8-20-2019 - County Comments, add parking

SITE PLAN

PROJECT No. 18326
 JANUARY 10, 2019
 SHEET 1 OF 1

Site Plan.pdf Markup Summary

SITE PLAN

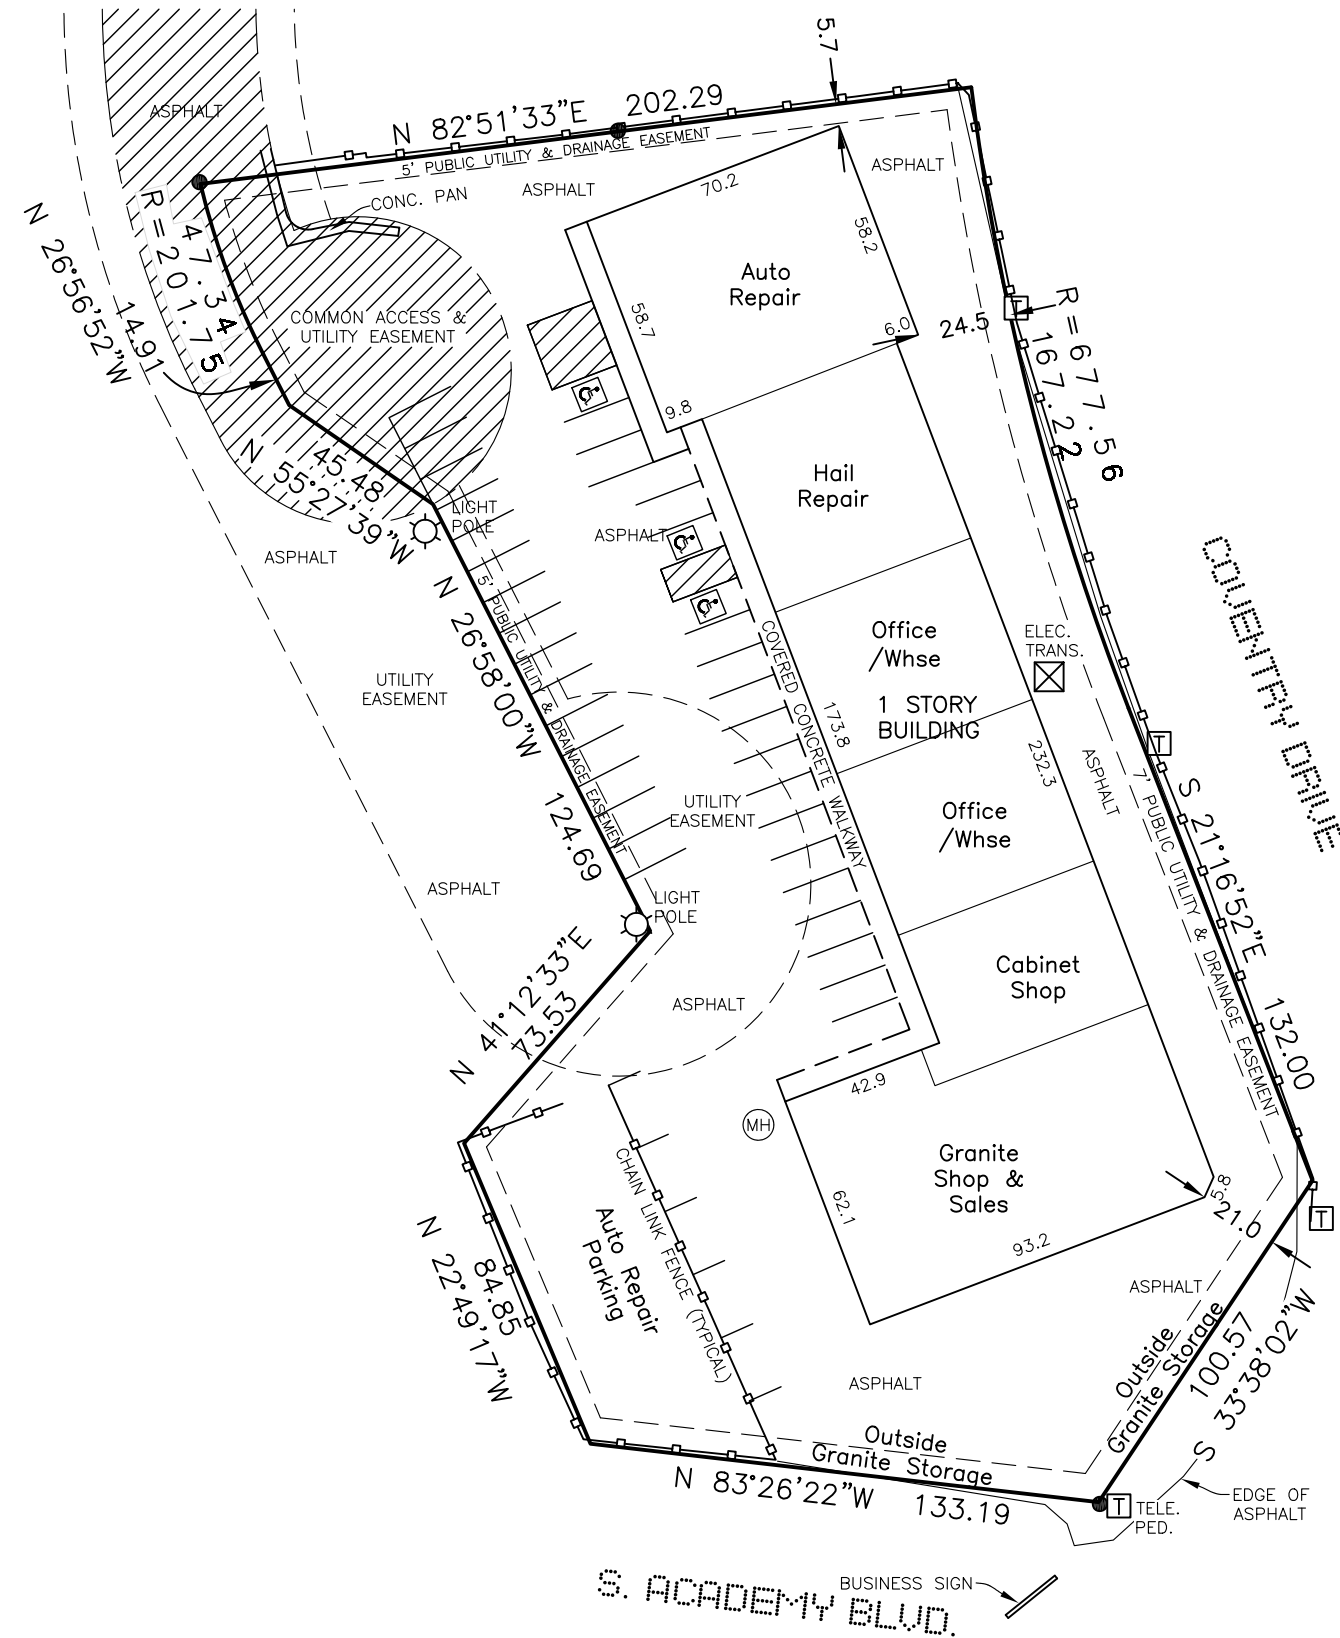
An alternative landscaping plan will be required - see section 6.2.2 of the land development code
 Parking detail is required for each use - see chapter 6 table 6-2 for parking requirements and uses
 Loading area and bays must be shown for parking detail

Screening of outside storage is required per 5.2.37 of the land development code

Parking cannot be within easements

Upon inspection by Planning staff, auto repair parking is also outside storage and must be screened
